# cd-review1.pdf Markup Summary

**AS PLATTED**

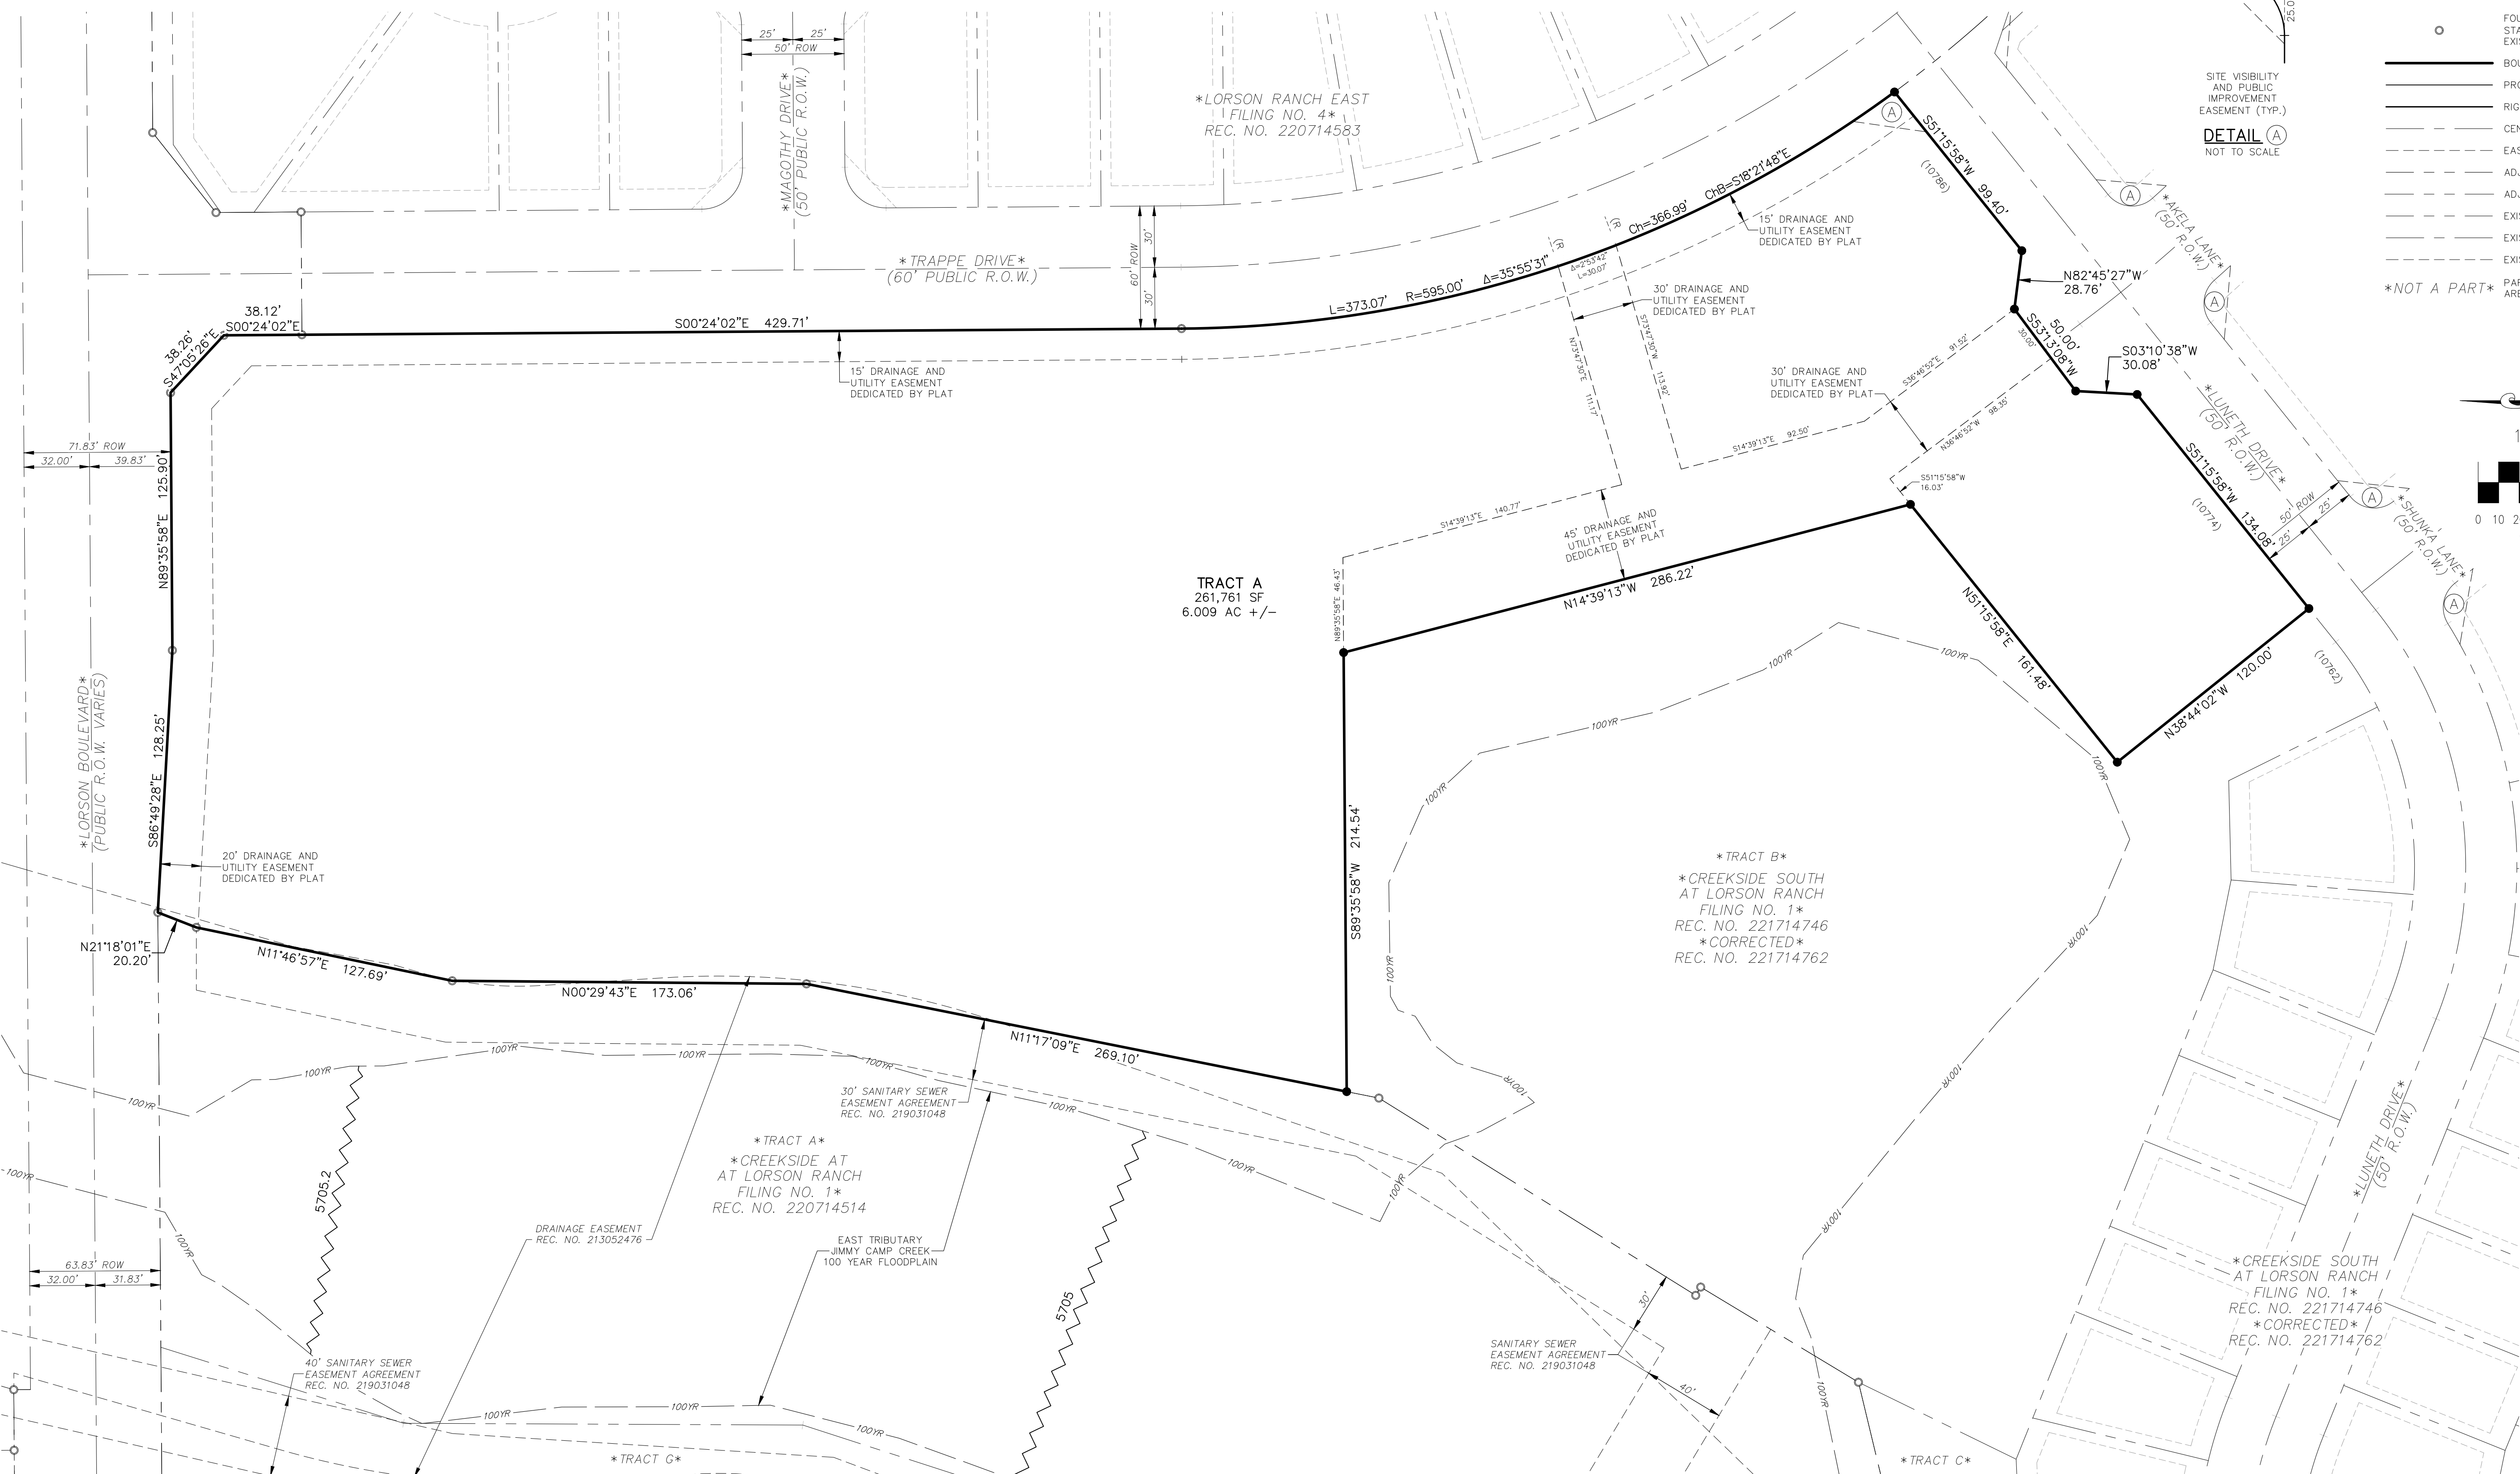
Plat shows min distance as 25' min. Please coordinate between this sheet and plat so details have the same information.

plat updated

TYPICAL SECTION 50' R.O.W.
RESIDENTIAL URBAN LOCAL
NOT TO SCALE

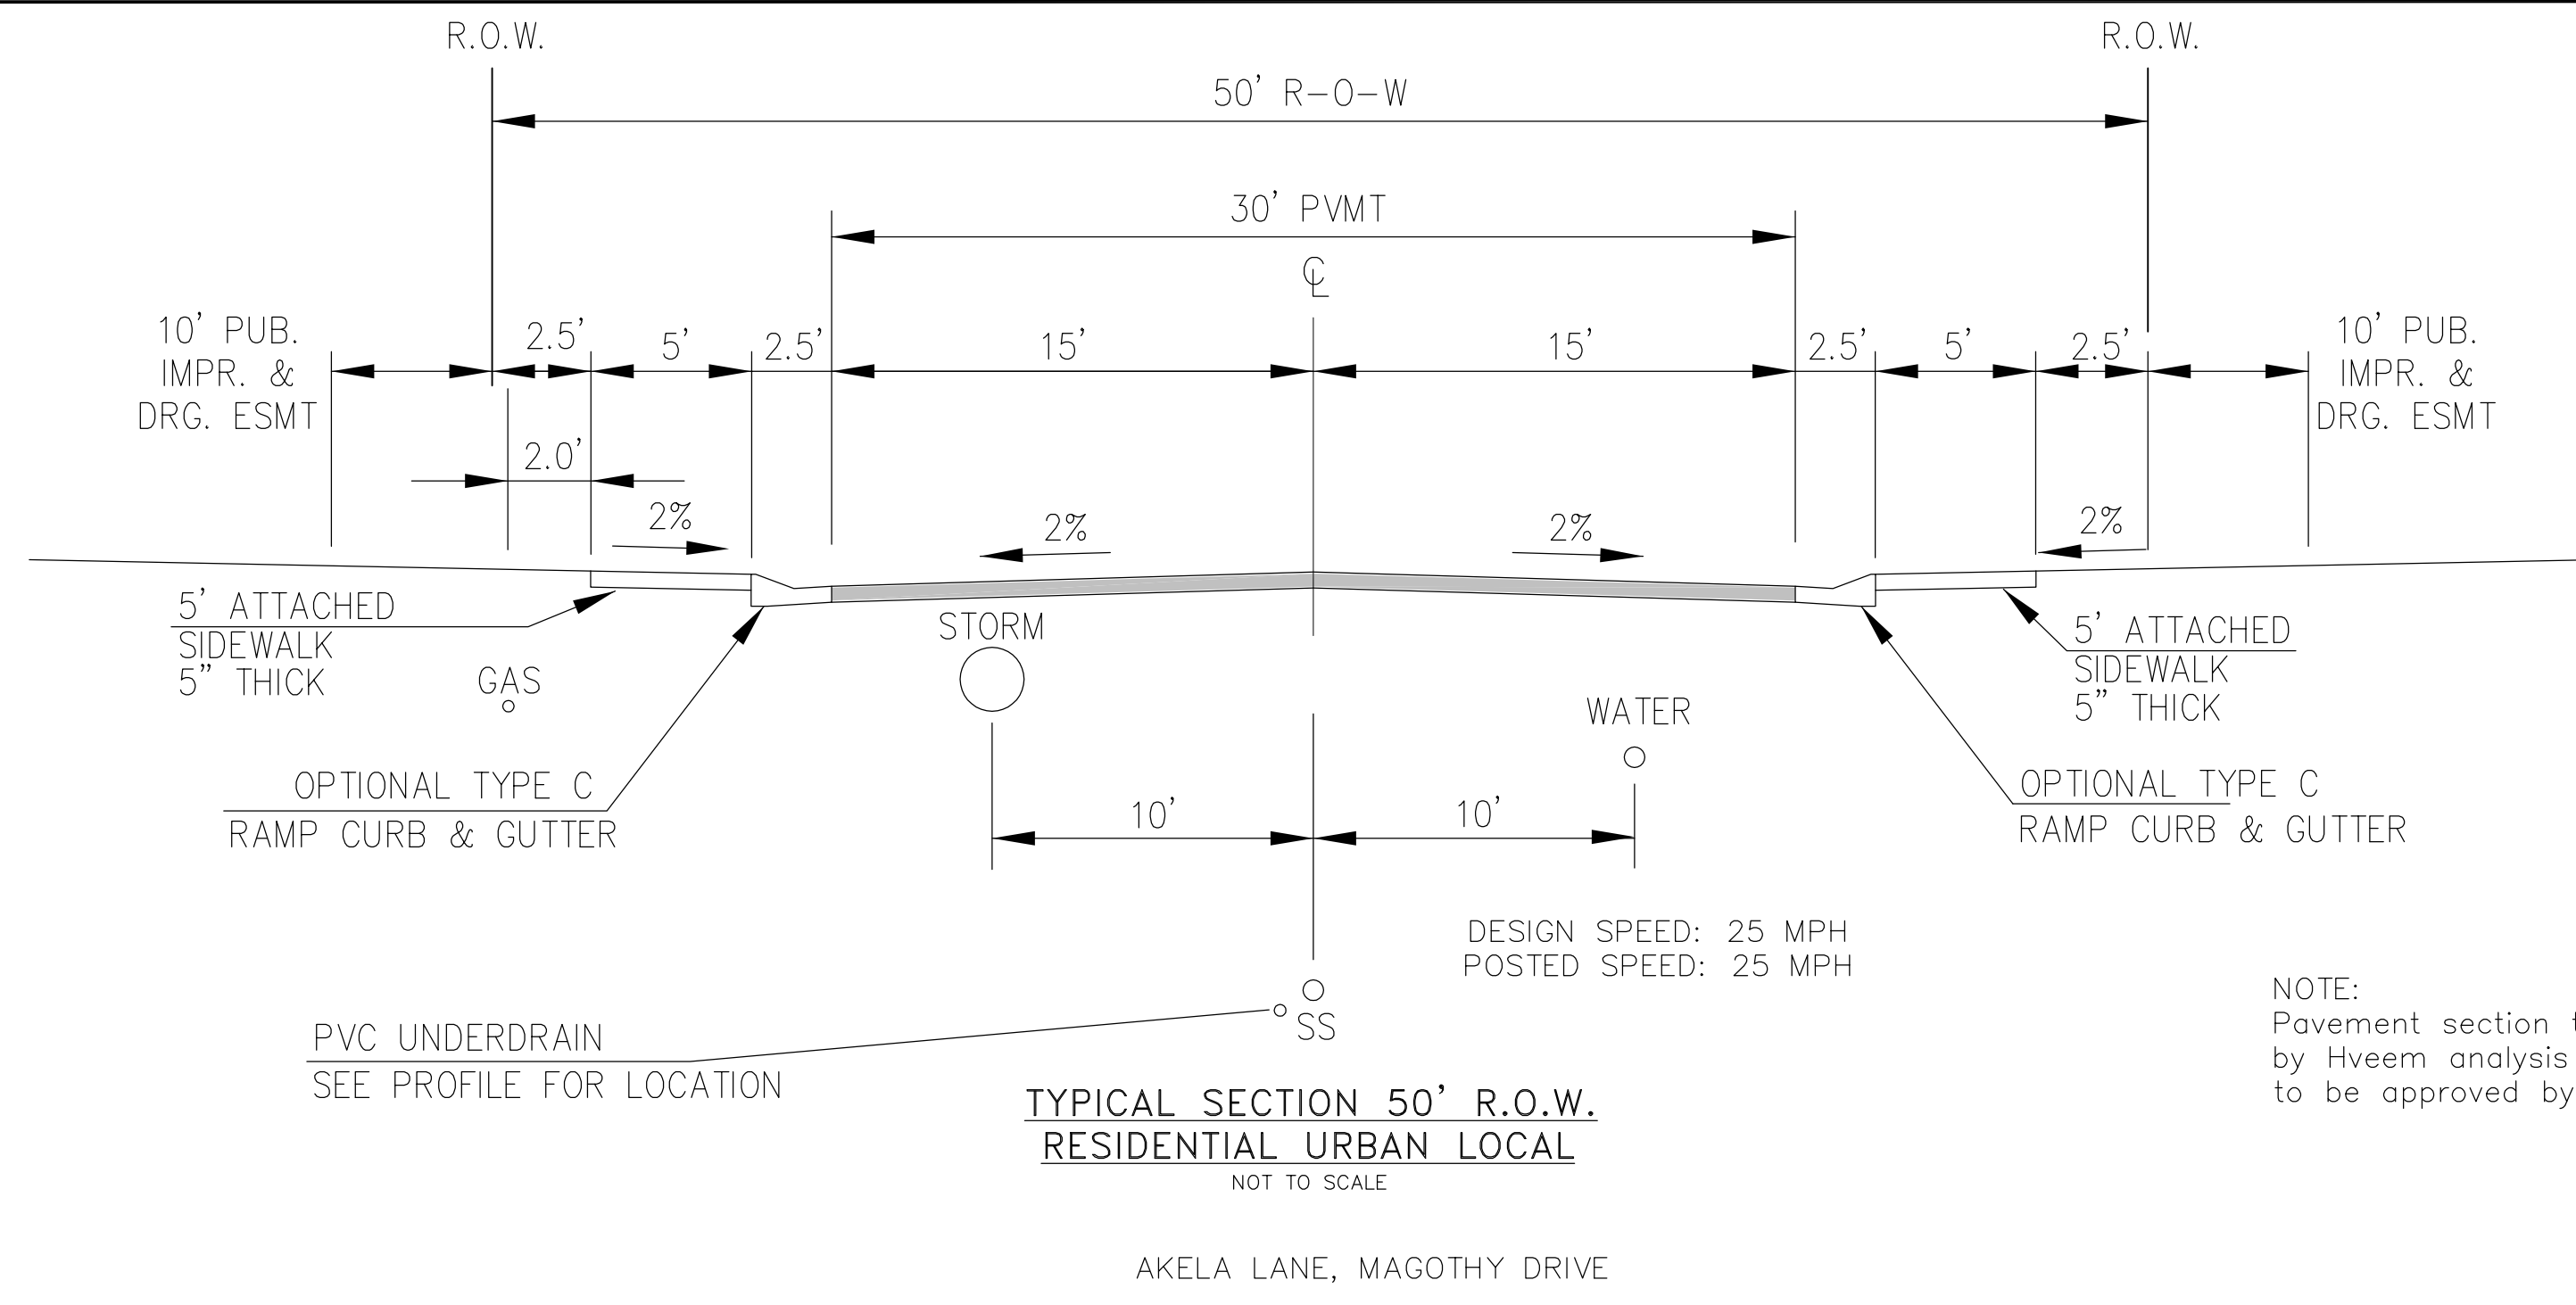
Per typical section on GEC plan set, public improvement easement is 10'. Update sections between plan sets to be consistent.

change grading plan to 5'
